2023/0332

Erection of two storey extensions to the rear and side of dwelling with single storey front extension.

84 Newtown Avenue, Royston, Barnsley, S71 4HB

Drawing Title  
**PROPOSED ELEVATIONS**

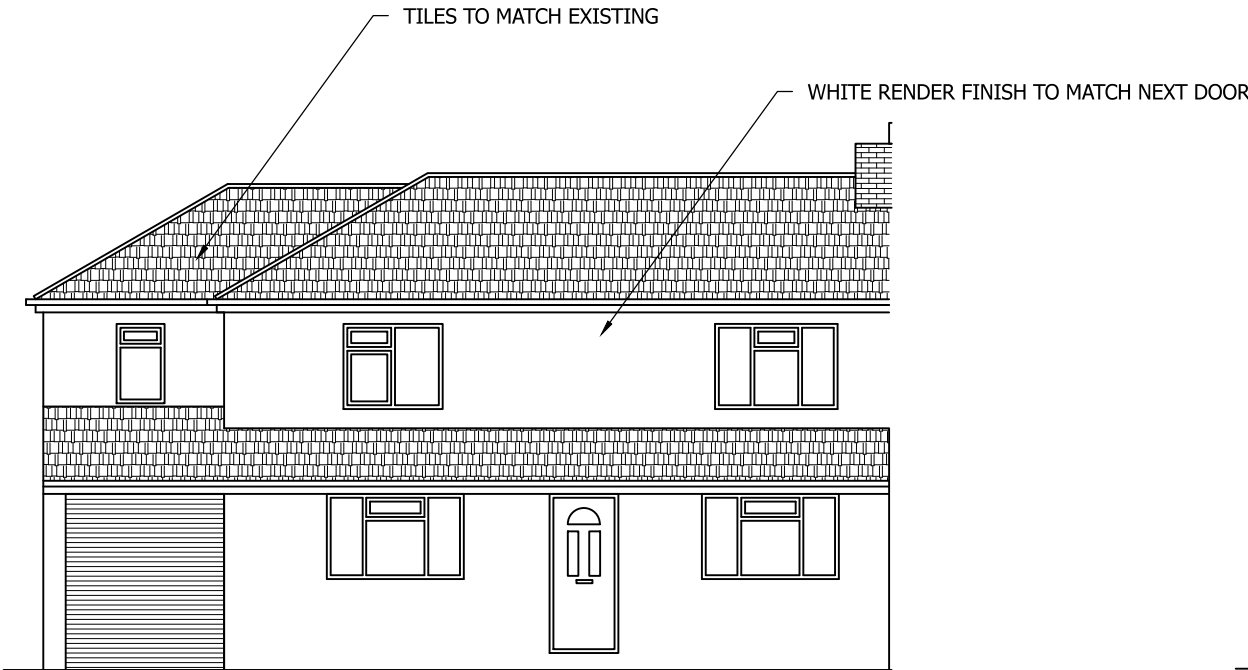
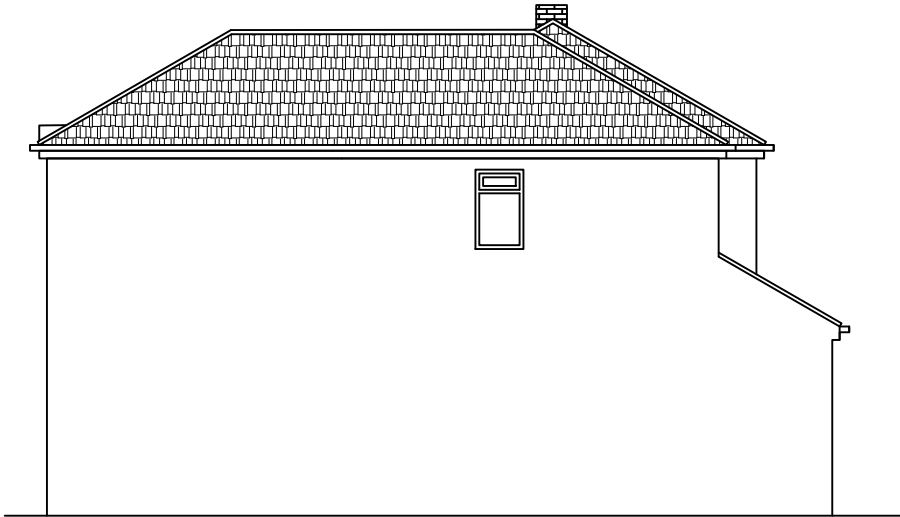
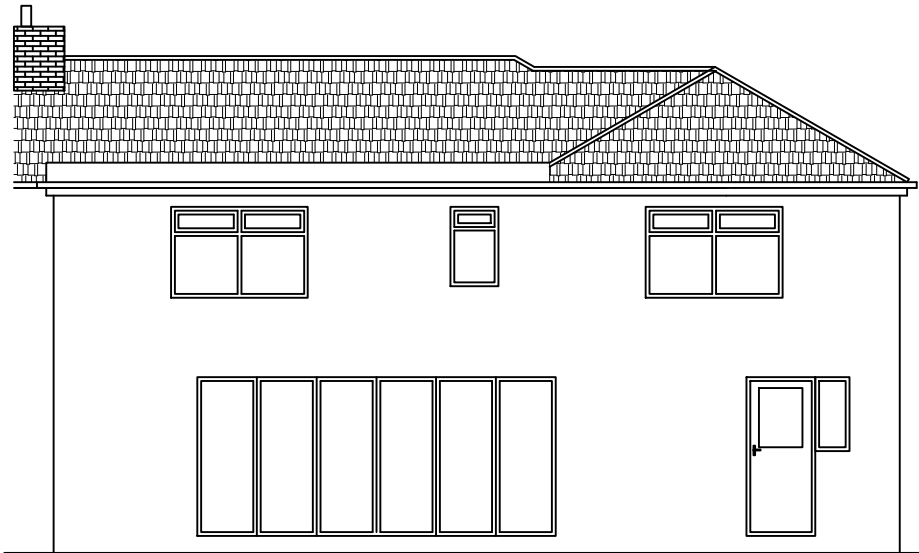
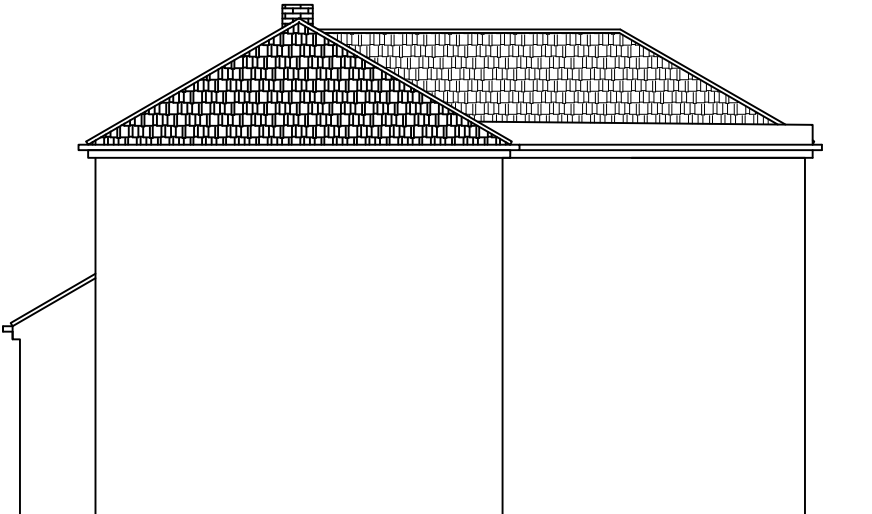
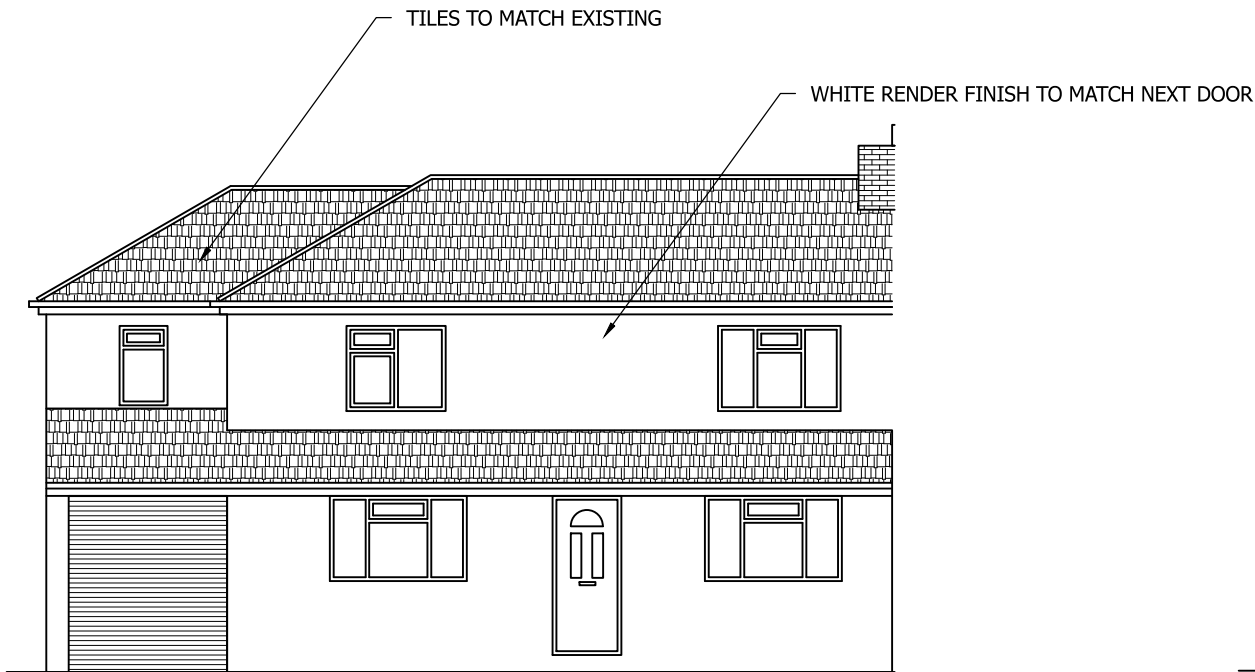
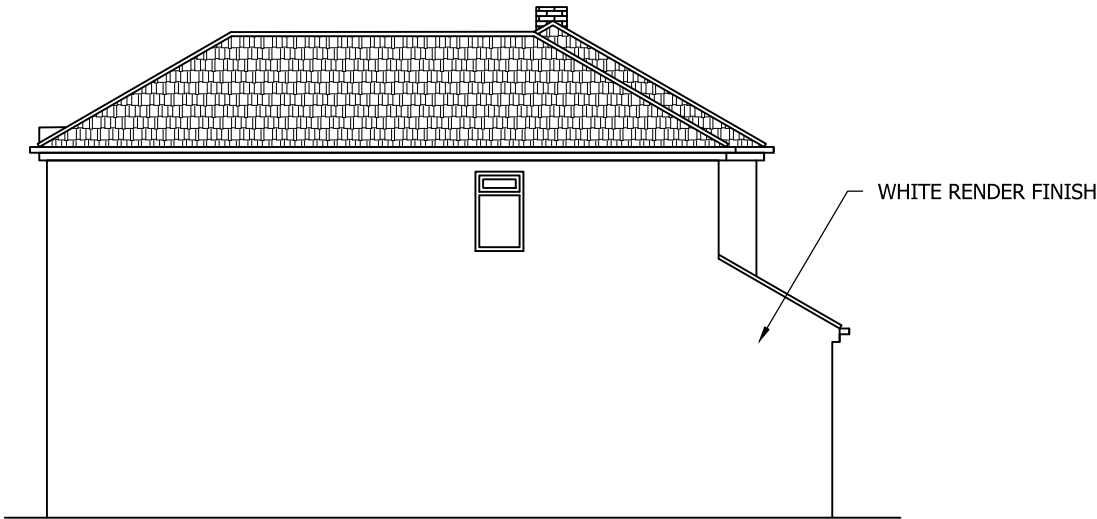
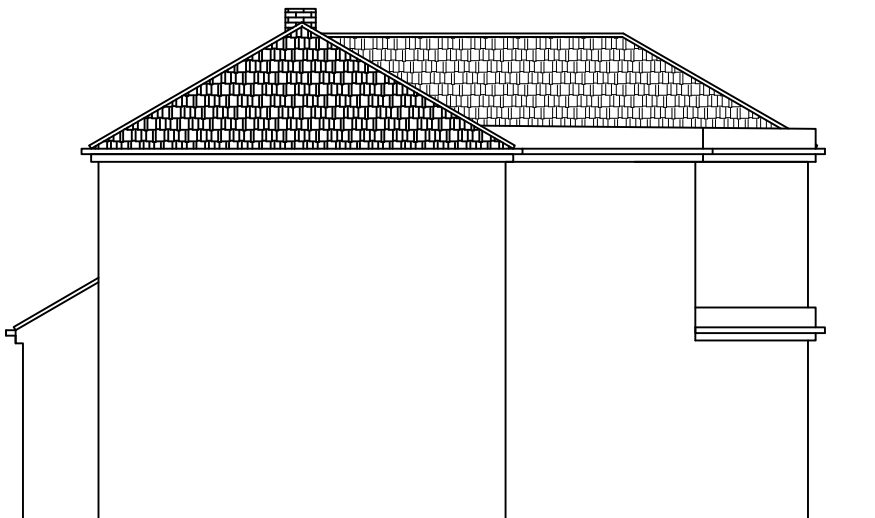
It is noted that the neighbouring extension has been designed to limit the impact on the application site, in particular a first-floor habitable room window located adjacent to the party boundary. The applicant was requested to amend the submitted plans to afford the same level of protection to the window on the neighbouring property 82 Newtown Avenue.

Amended plans have been submitted which ensures that the 45-degree quadrant from the mid-point of the upper floor window at 82 Newtown Avenue, and as such it is not considered that the proposed extension would lead to a reduction in outlook or increase levels of overshadowing to a detrimental level. This quadrant has also been applied to the neighbouring property to the south, to assess the impact on 86 Newtown Avenue. Due to the design and location of this property in relation to the application property, the proposed two-storey side and rear extension would not intersect the 45-degree quadrant, therefore not resulting in a significant loss of outlook from this property.

PROPOSED FIRST FLOOR PLAN
SCALE 1:100 AT A3

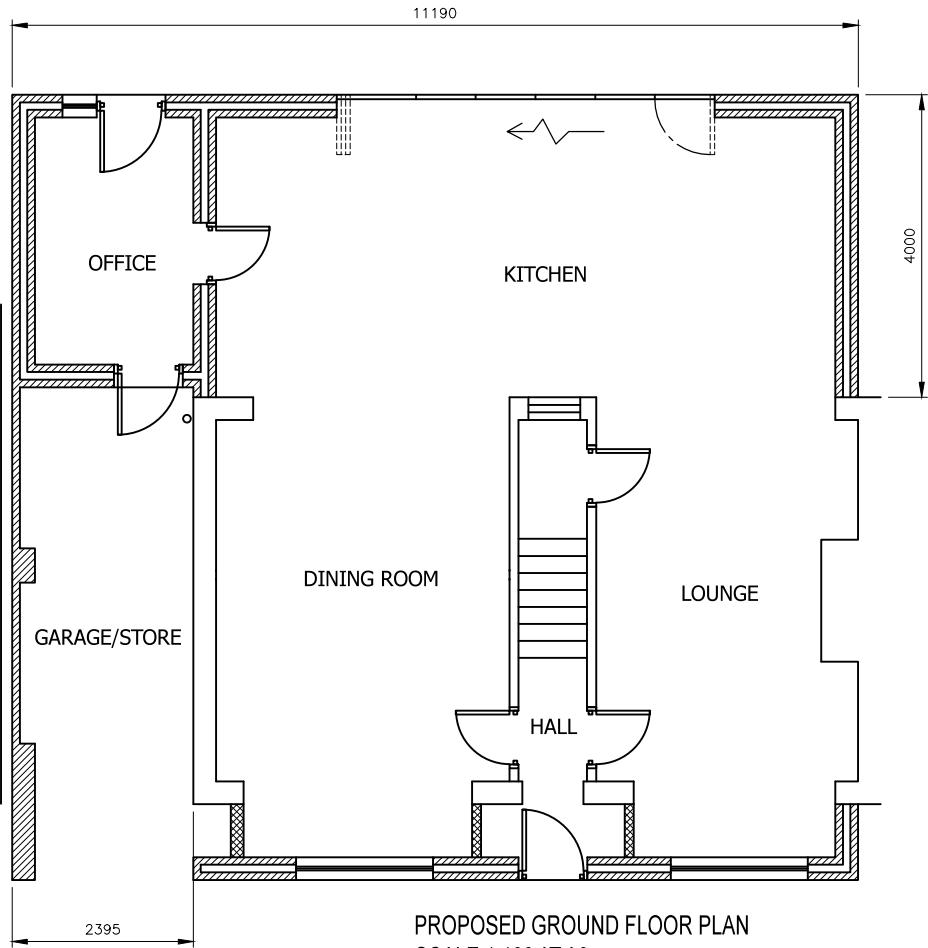
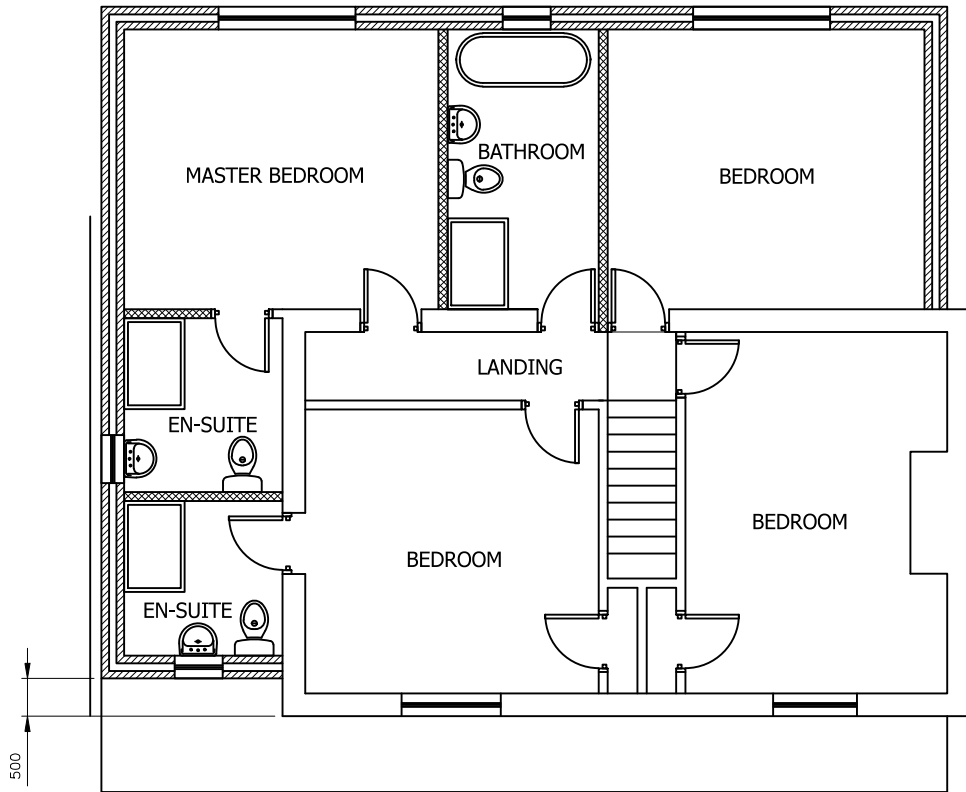
There are no habitable room windows located on the side elevation of the proposed extension, therefore there would be no increase in levels of overlooking, whilst an en-suite window is located on the side of the proposed extension, it is not classed as habitable. nevertheless, it is considered prudent to condition the installation of obscure glazing to protect the amenity of the occupants of both properties. The windows located on the front elevation does not project closer to the front boundary than the existing dwelling, and those located on the rear elevation are situated in excess of 10m to the rear boundary.
